The Five Village Society

4th March 2019

Ref : Y/8/19/PL - Hazel Cottage, Church Lane, Yapton
Single storey extension linking garage to existing
house including conversion of existing garage to
habitable use

PROJECT TITLE Proposed Development at Hazel Cottage Church Lane Yapton Arundel	DRAWING TITLE Proposed Elevations		No	REVISION	DATE
	STATUS Planning Application				
	SCALE 1:100 @ A3	DATE 03.01.2019			
	DRAWN BY DE	DRAWING NO PA-302-06

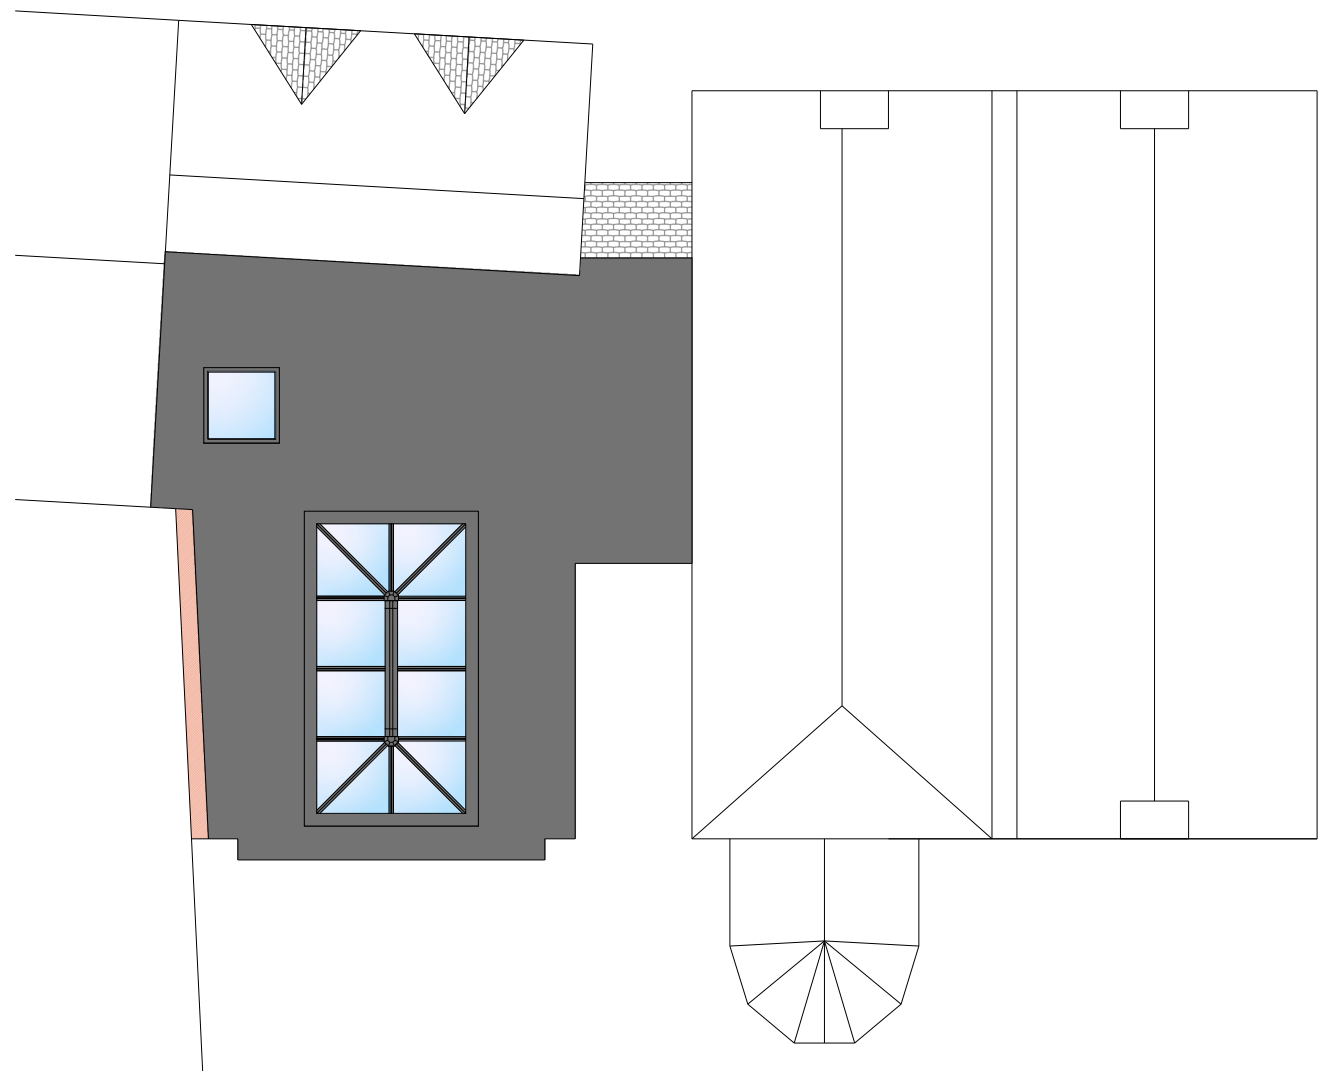
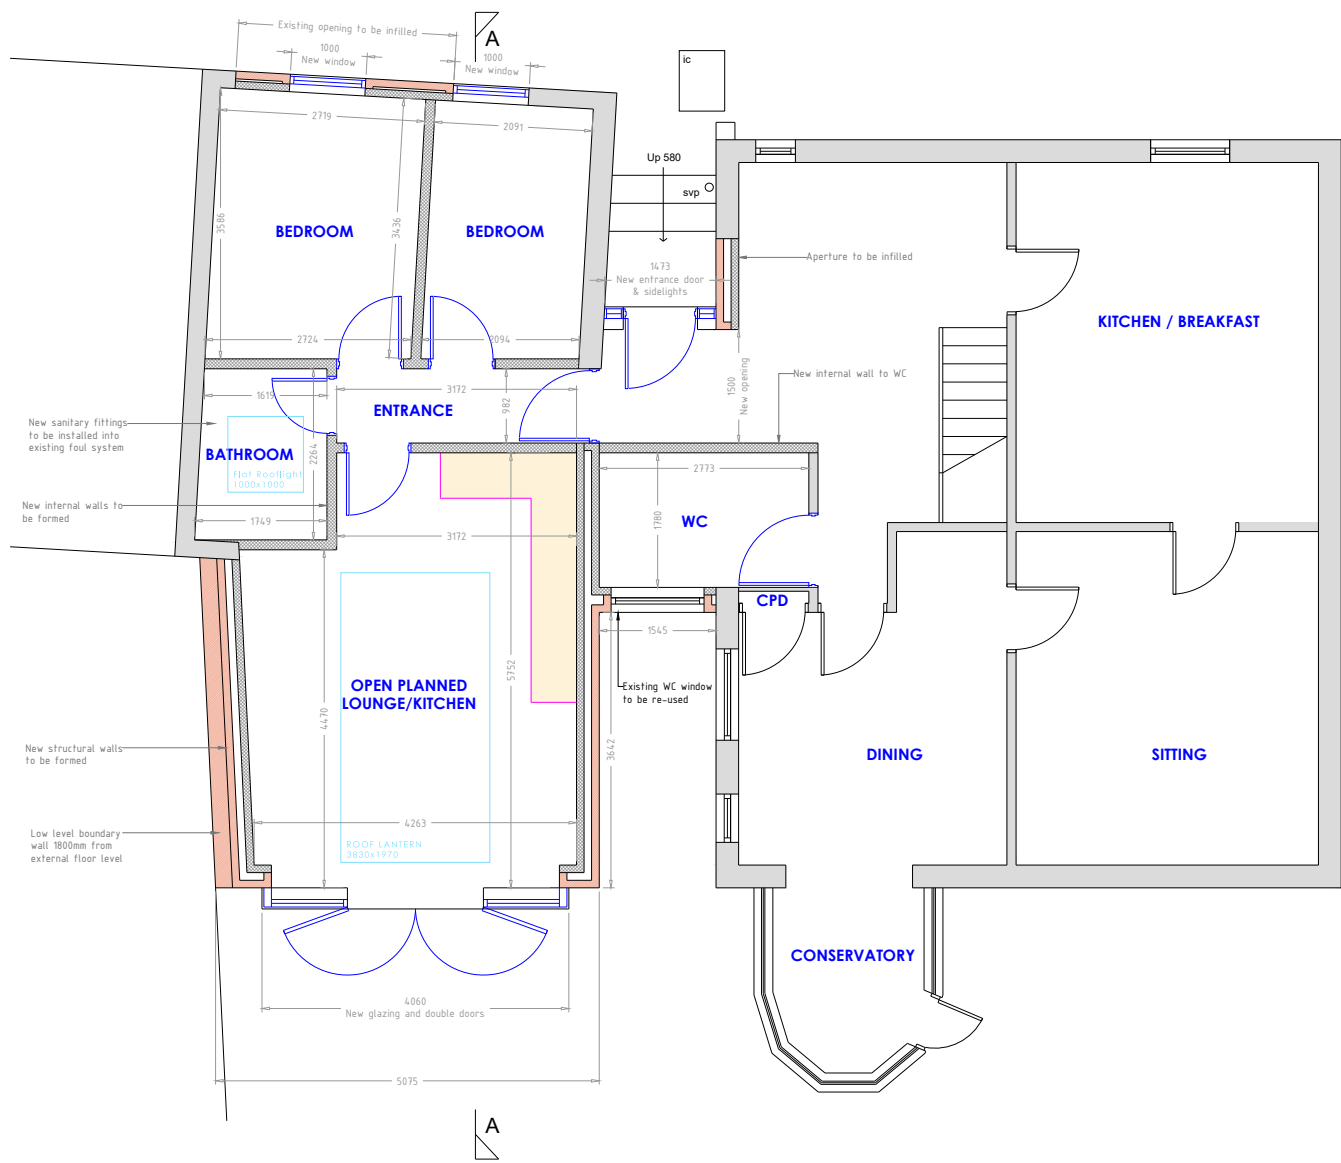
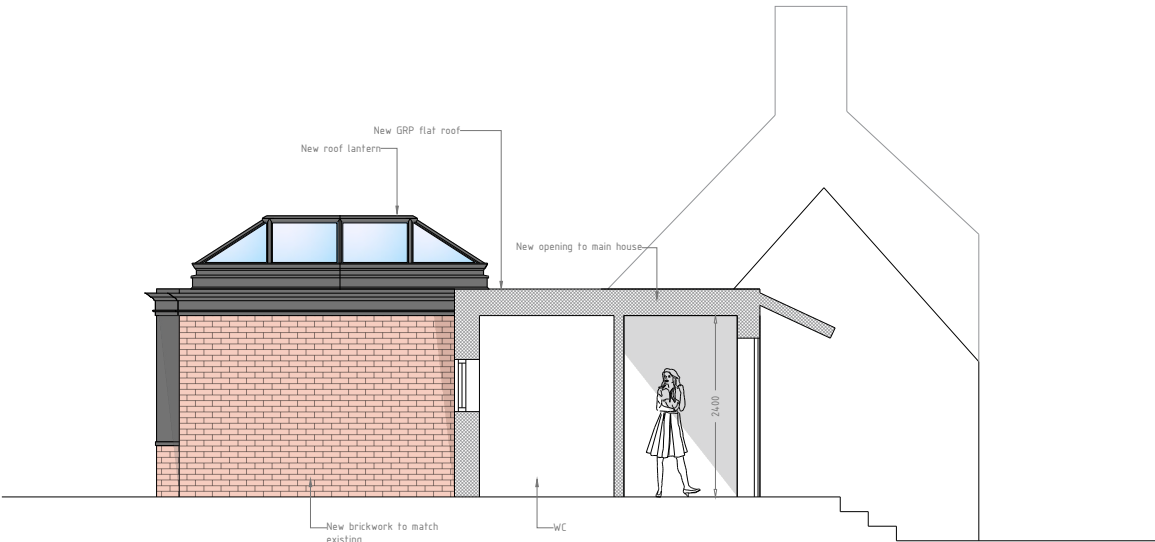
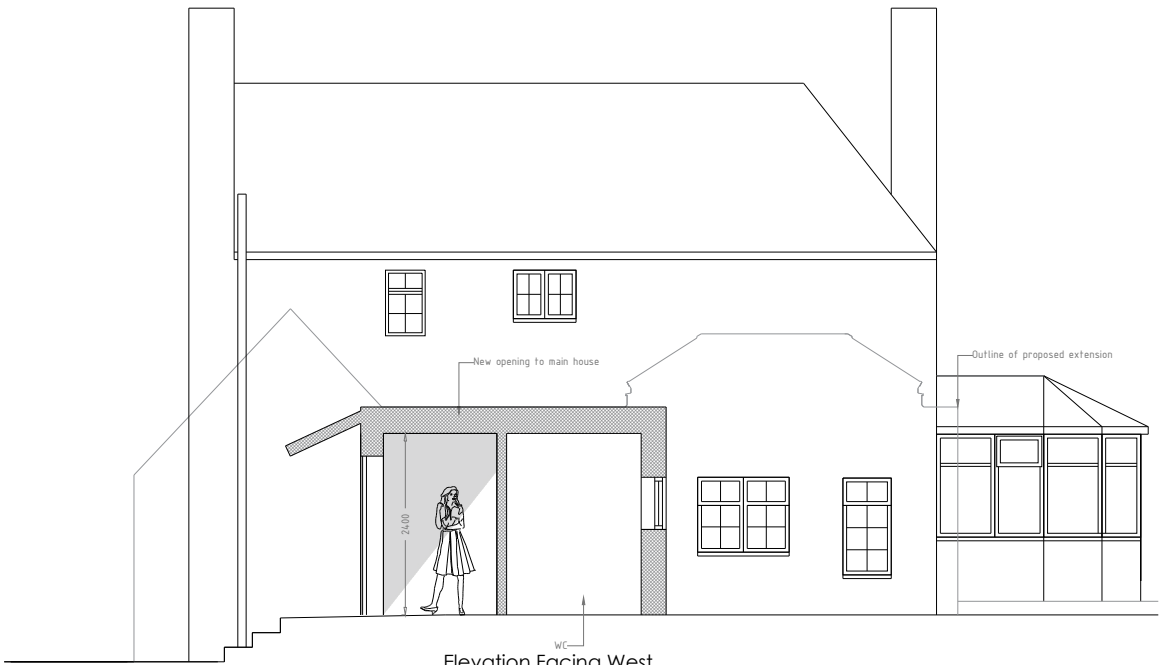
- 1) The proposed development will affect the character and setting of Gr. II Listed Building "Twelfth of Never". The single storey flint garage between forms an attractive part of the street scene and should be retained unchanged.
- 2) The narrow alley between Hazel Cottage and the flint garage is a significant space which clearly separates the style of the properties and should not be filled in.
- 3) The proposed design with dormer windows is intrusive and out of character with adjacent window styles. It would in no way enhance the street scene.
